Land North East of Oxford Road West of Oxford Canal and East Of Bankside, Banbury, Oxfordshire

Technical Note: Response to Oxfordshire County Council's (Drainage) Comments dated 12th May 2020 for Application 19/01047/OUT-2

22nd May 2020

Infiltration Basin
 Total Contributing Area (ha): 23.00
 Design Infiltration Rate (m/s): 9.06x10⁻⁵
 Total Storage Volume (m³): 7,410
 Total Basin Area (m²): 7,266

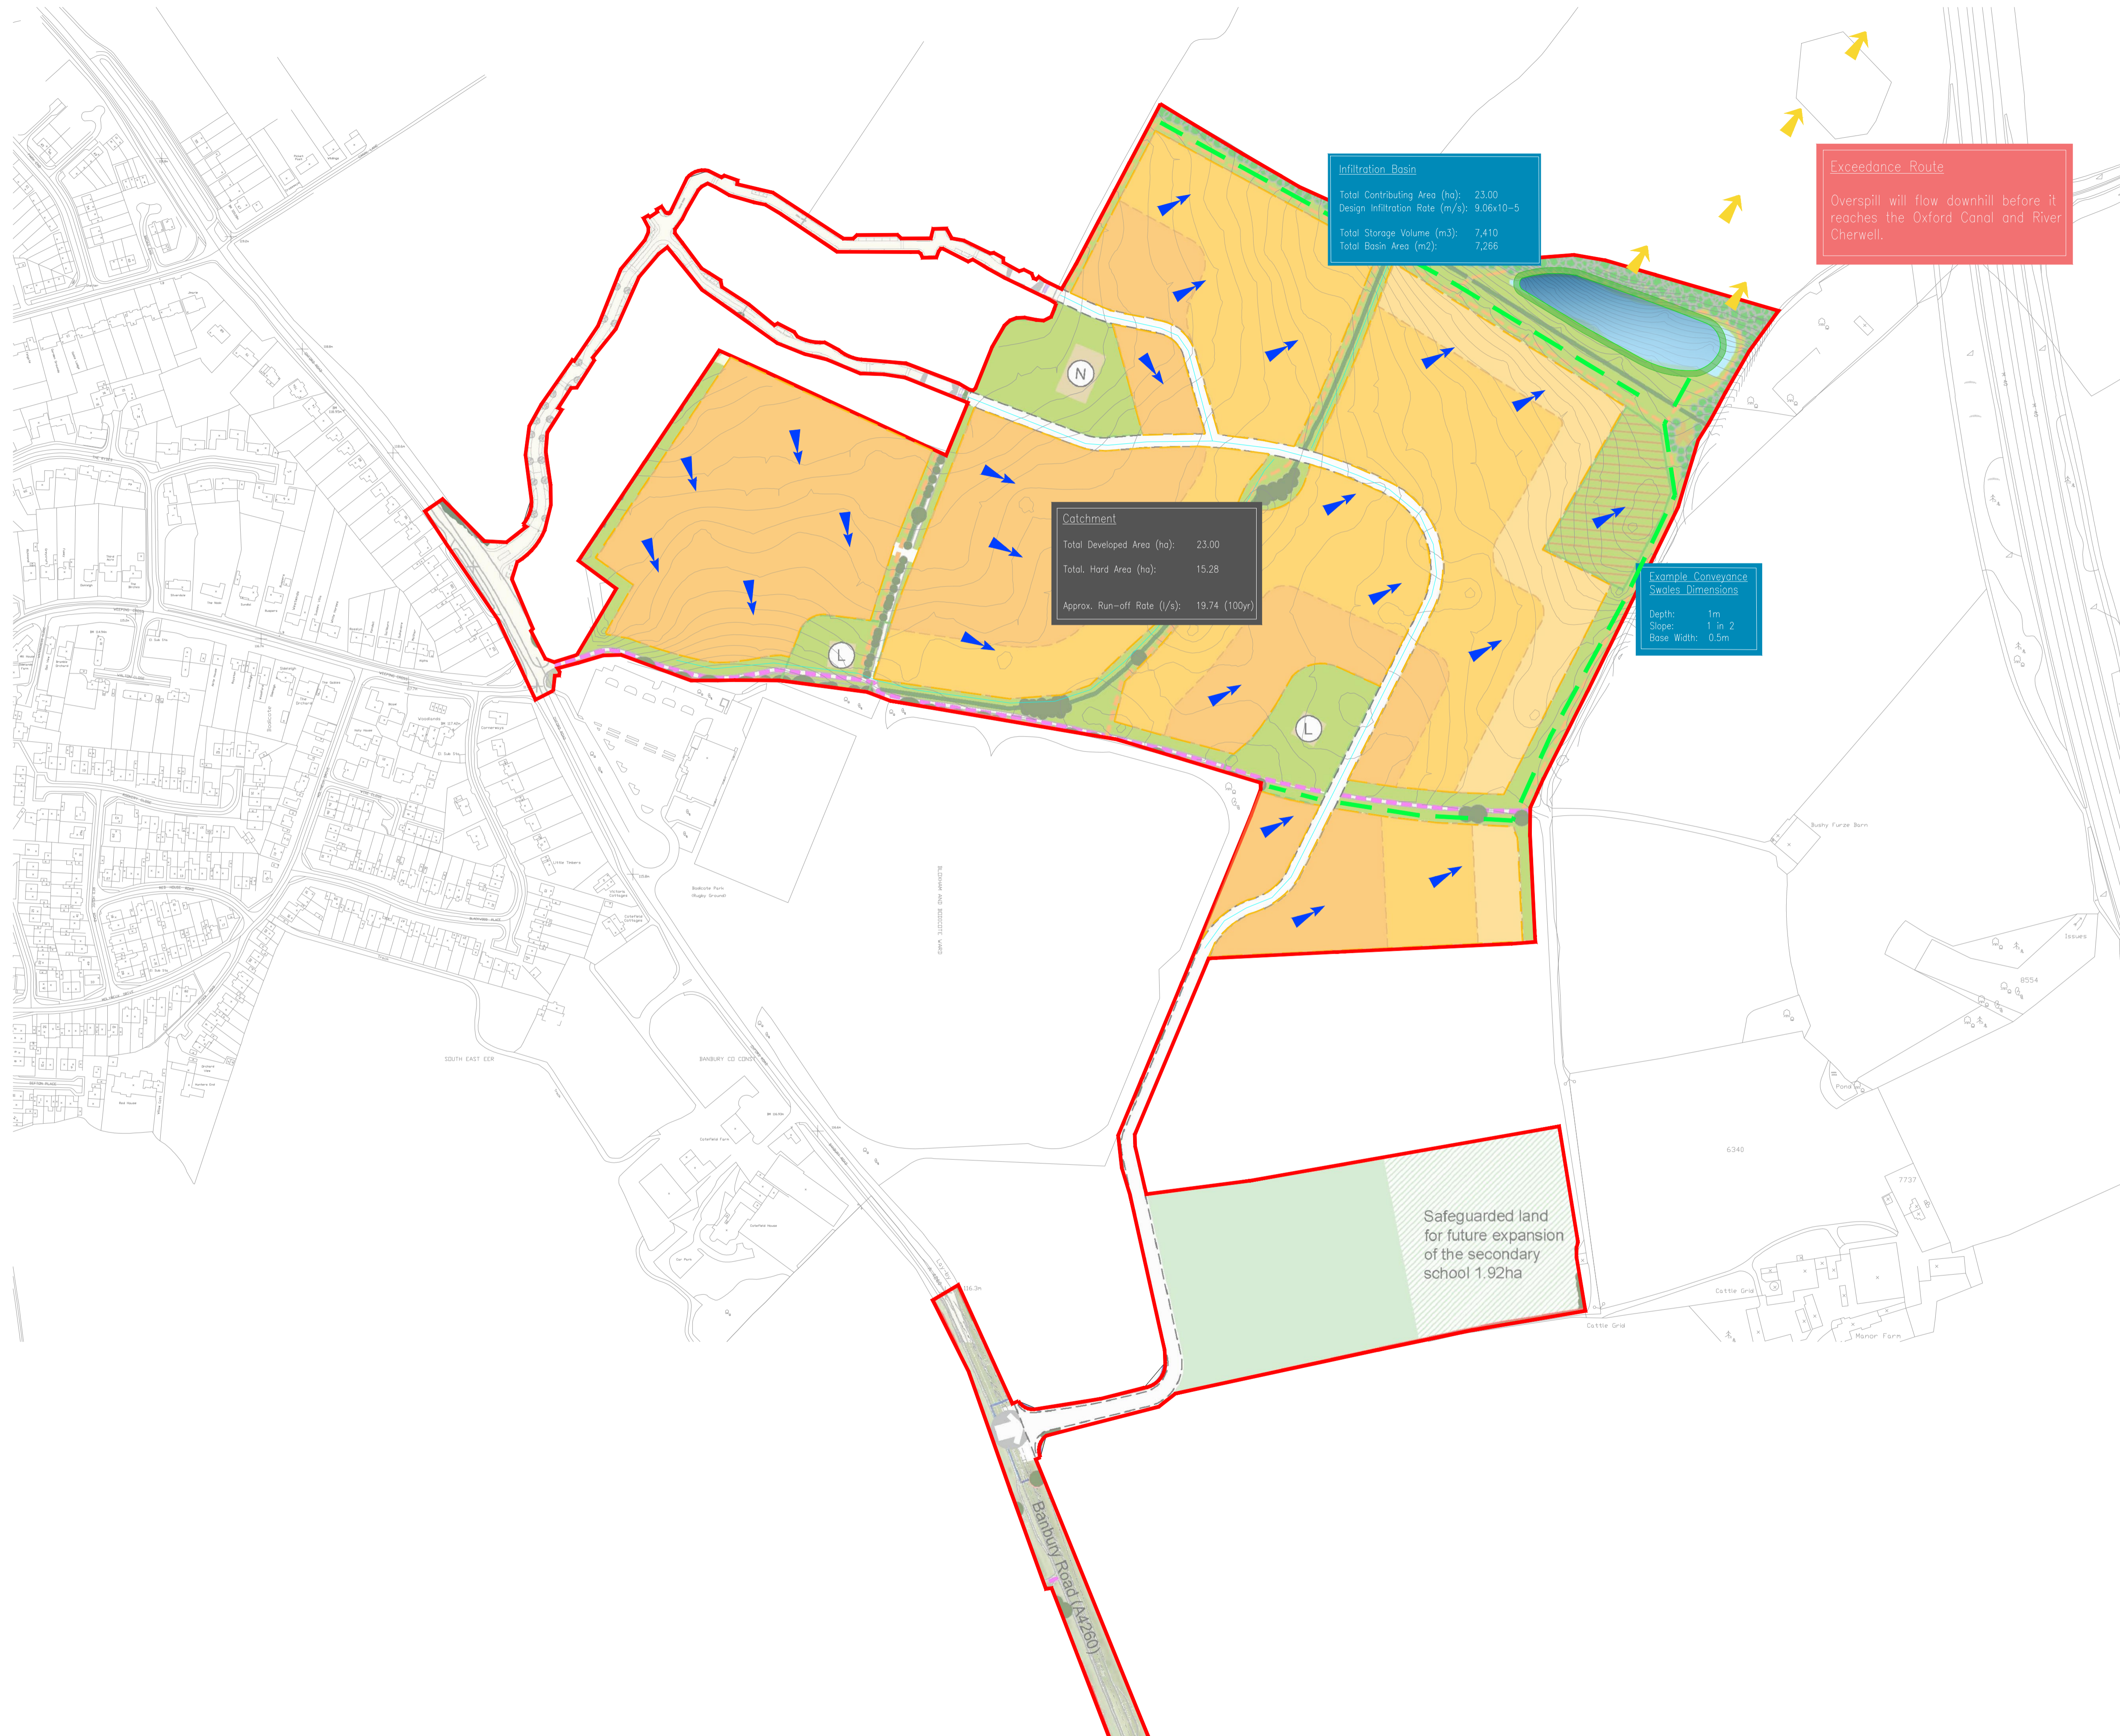
4. *MicroDrainage calculations provided use default Cv values, these are not representative of the site. It is recommended values of 0.95 for roofs and 0.9 for paved areas are applied. The designer must justify where a Cv of less than 0.9 has been used.*

Phasing for the development will be determined at Reserved Matters. Currently the drainage plan (DR-05 Rev E) illustrates how each residential parcel will discharge its surface water into the basin which is located at the lowest point of the site. Many factors as well as drainage will determine phasing and the interim drainage for that must be completed at the appropriate time. i.e. RM or detailed application stage.

12. *Conveyance routing around site needs to be demonstrated.*

15. *Safe ingress/egress needs to be demonstrated.*

16. *Sacrificial areas in the event of exceedance should be considered.*

The default Cv values have not been used for this design. As outlined in your previous comments (19/01047/OUT, 26th July 2019) a value of 0.925 was then used within the basin design. As this is an outline application the masterplan has yet to be fixed, therefore, we have continued to use 0.925 Cv value as a compromise between the amount of roof and paved area that will be provided within the site. Microdrainage calculations for the detailed submission when exact roofing and paved areas are known can use specific Cv values.

The drainage strategy (DR-05 Rev E), located within Appendix B of the FRA, illustrates the proposed locations of swales and pipe network throughout the development. This network will convey surface water from the residential parcels to the infiltration basin located at the north east of the site.

A maintenance slope of 1 in 5 has been illustrated on the basin shown on the updated drainage plan (DR-05 Rev F) located in Appendix A of this note.

The drainage strategy (DR- 05 Rev E), located within Appendix B of the FRA illustrates an exceedance route for storm water should the basin depth be exceeded. This is shown by the yellow arrows and the key has been amended in the subsequent revised drawing revision F in Appendix A of this note.
